# CITY OF ALBUQUERQUE

September 26, 2012

**Re: Leyba Body Shop, 130 Tennessee NE,  
Traffic Circulation Layout  
Architect's Stamp dated 8-29-12 (K19-D146)**

Based upon the information provided in your submittal received 8-29-12, the above referenced plan cannot be approved for Building Permit until the following comments are addressed:

TRAFFIC CIRCULATION LAYOUT

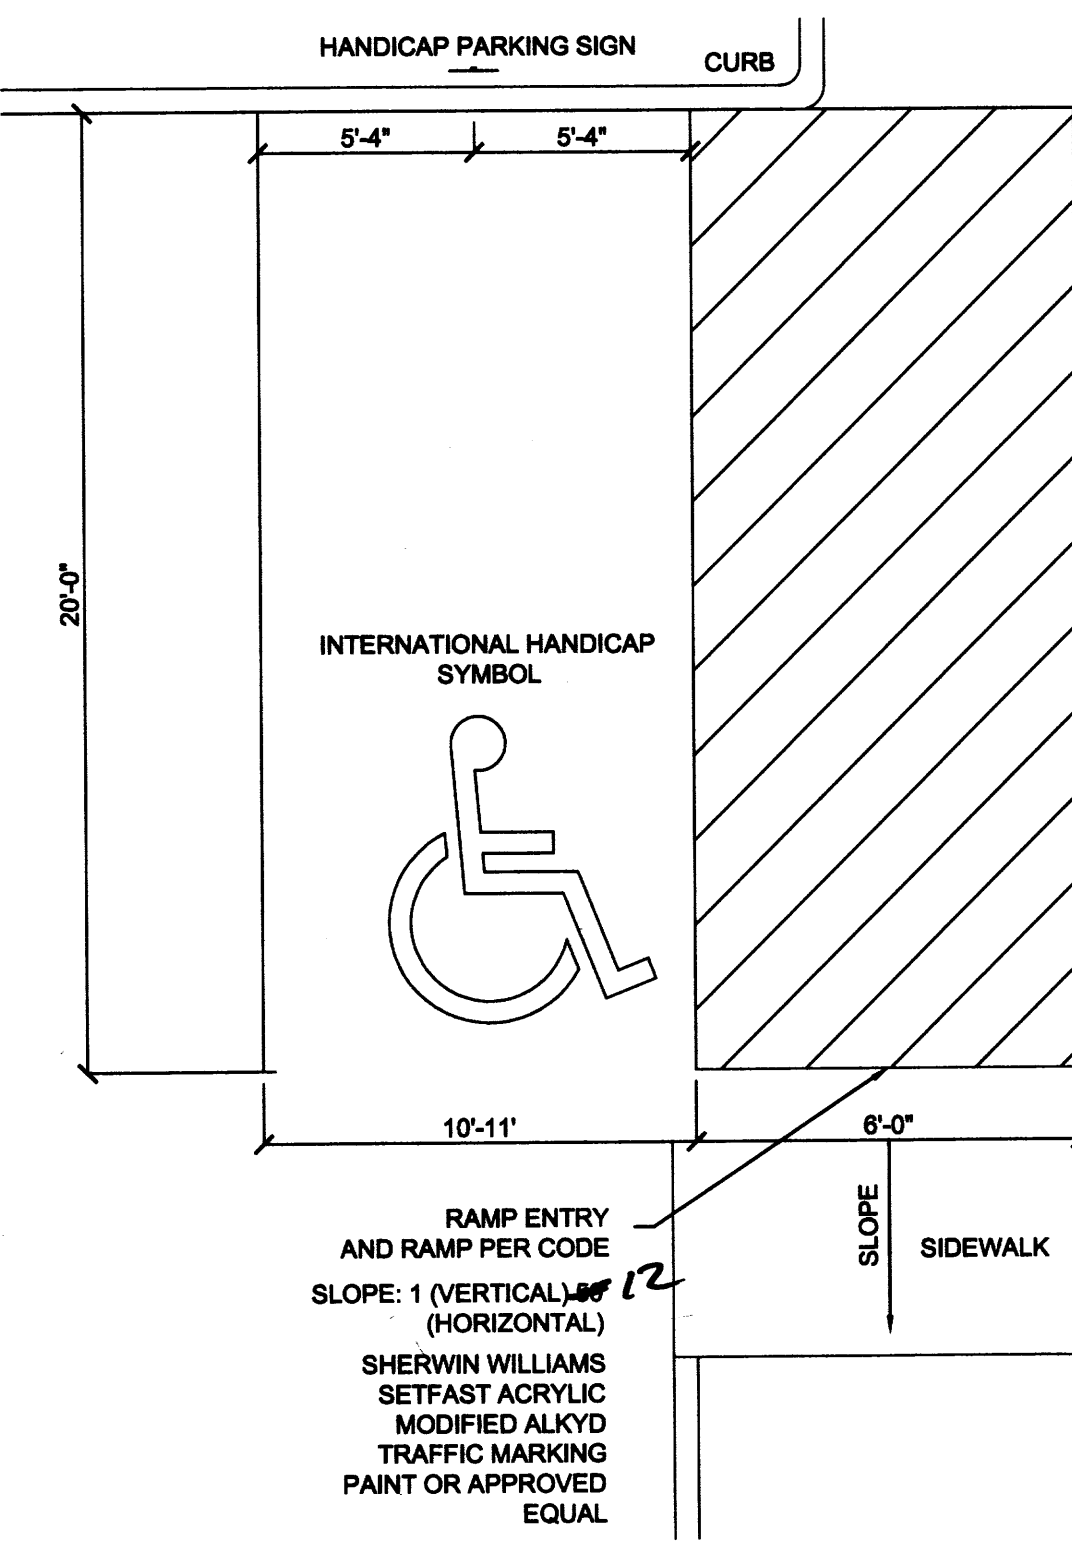
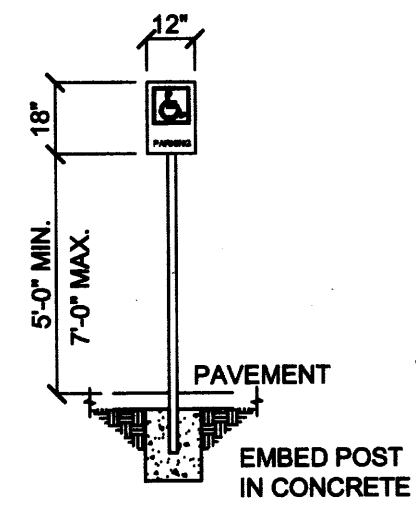
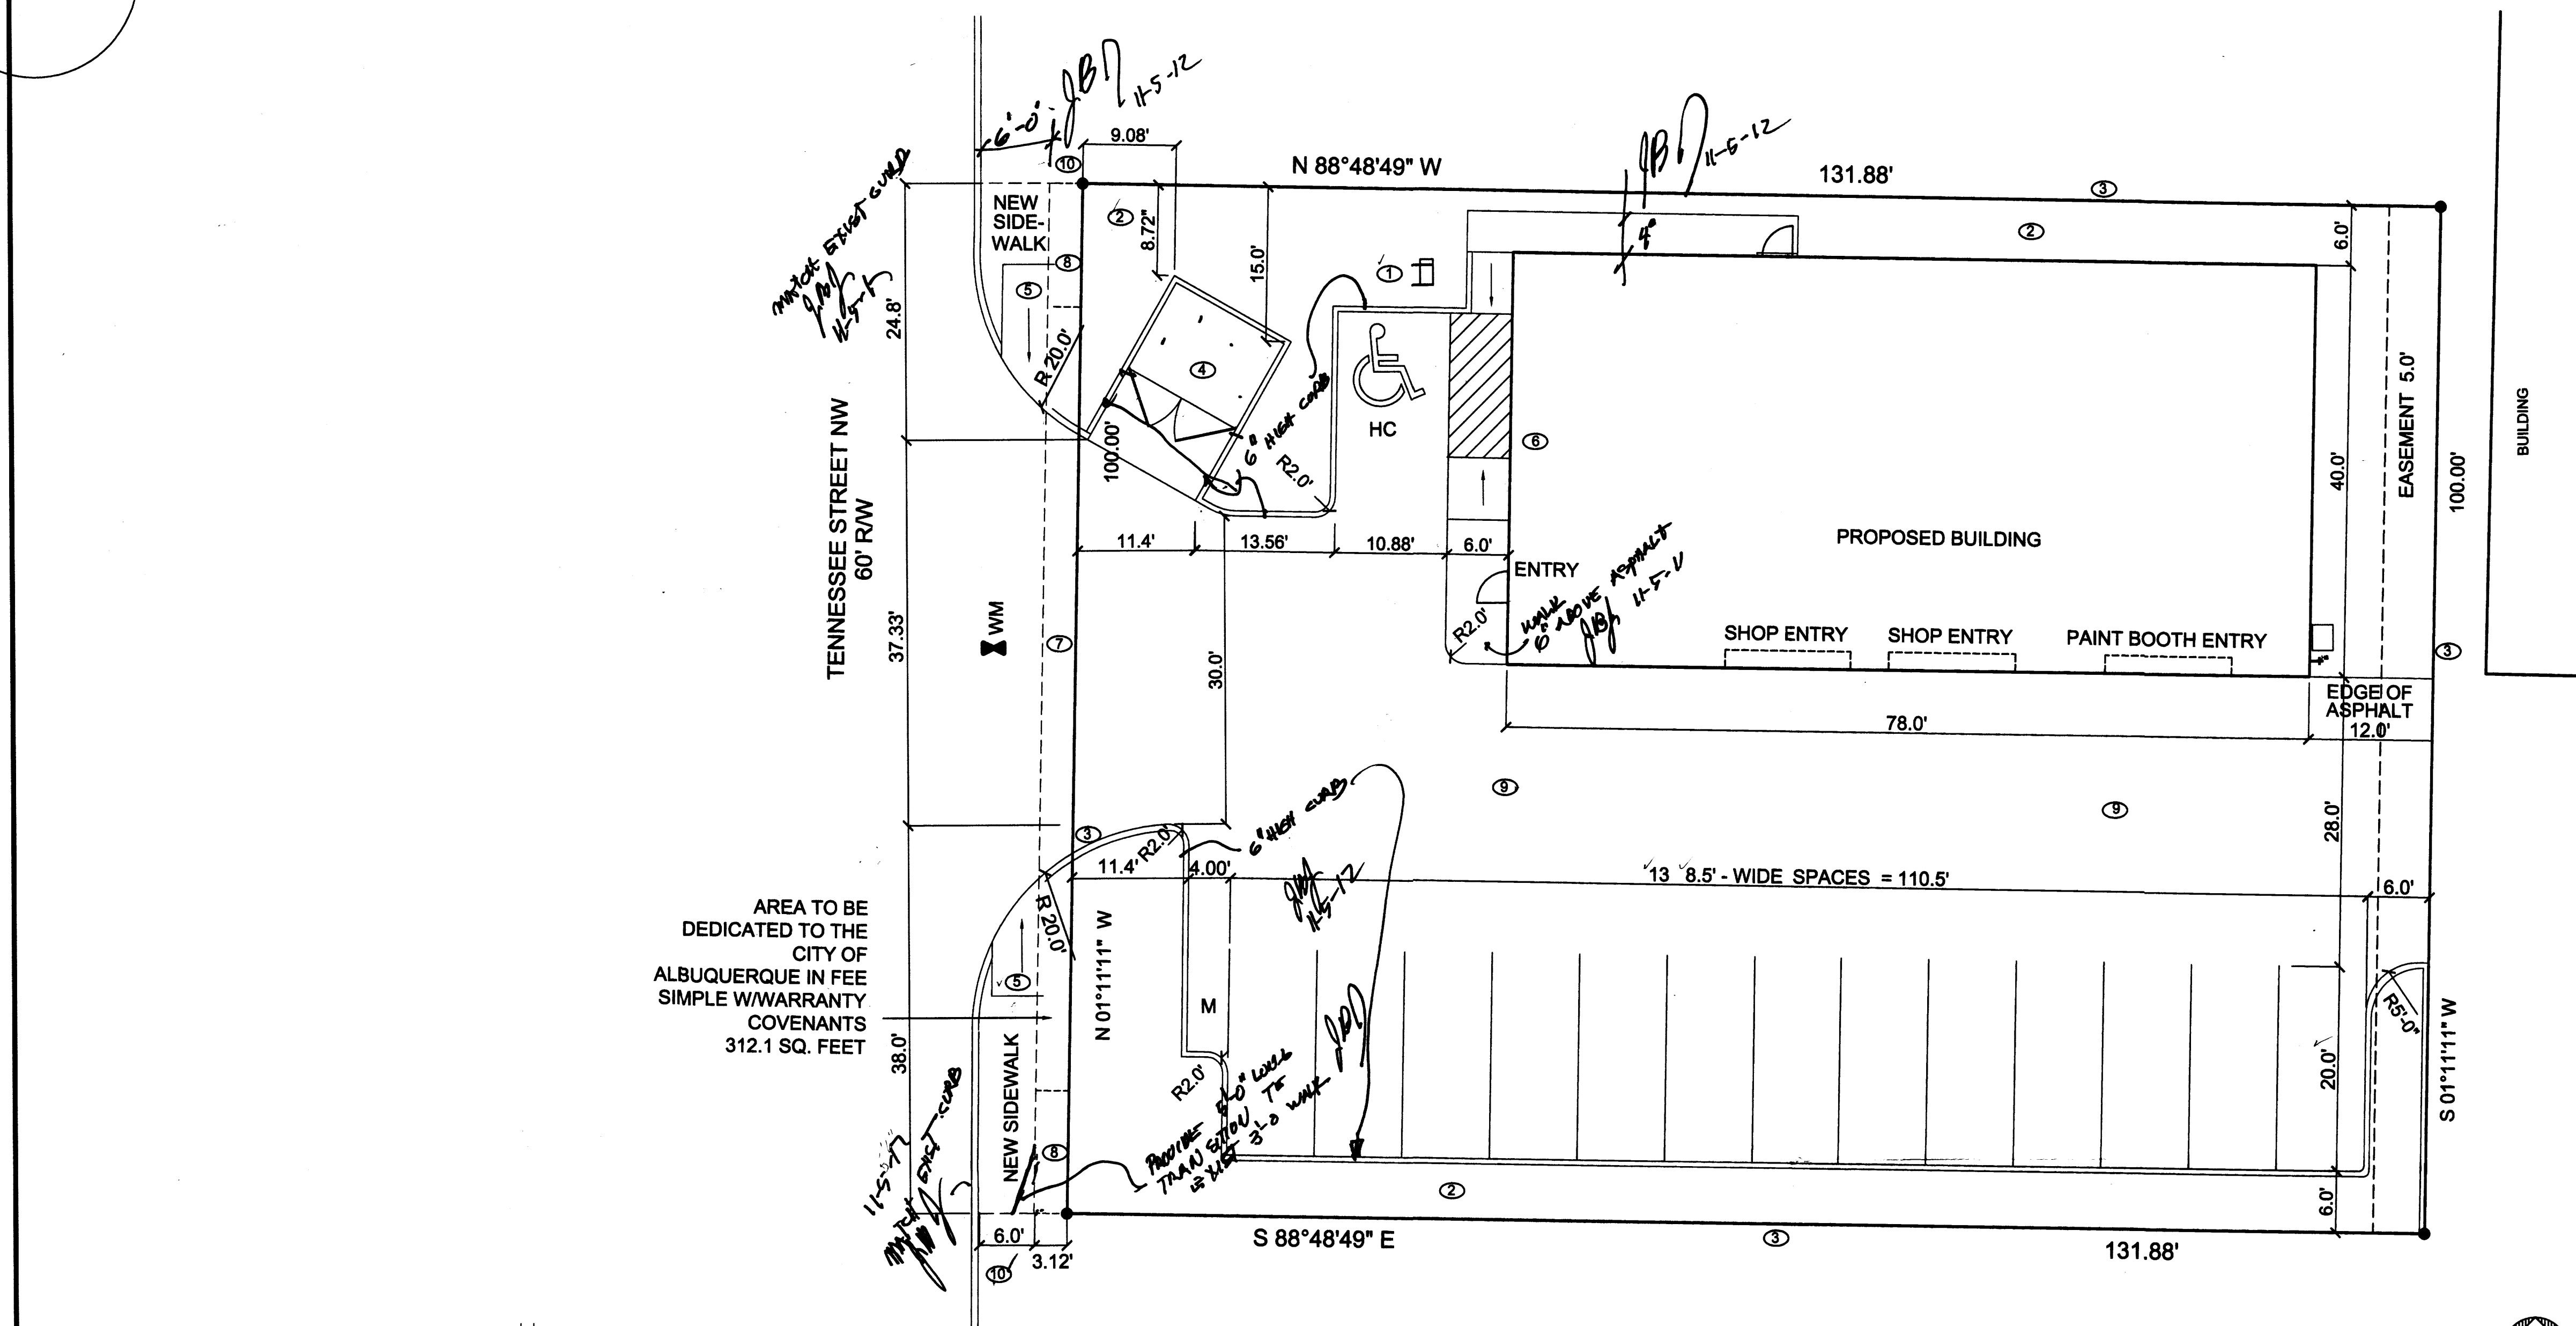
1. Please show the location of the nearest driveway on the adjacent lot.
2. Define width of the existing sidewalk.
3. The proposed ramp from ADA parking space is not an appropriate ramp for this layout.
4. Clarify the location of the existing drives (to be removed).
5. What is the status of the replat?
6. A 20-foot minimum radius is required for the entrance.
7. ADA parking must be protected from vehicular traffic.
8. Refuse doors conflict with the vehicular pathway.
9. Provide the legal description on the site.
10. The entrance and ADA ramp crosses into the adjacent lot. Please revise.
11. Keyed note 5 refers to "DWG 2425." This detail is for curb cuts, which do not utilize ramps. Please revise this note to refer to Standard 2426.
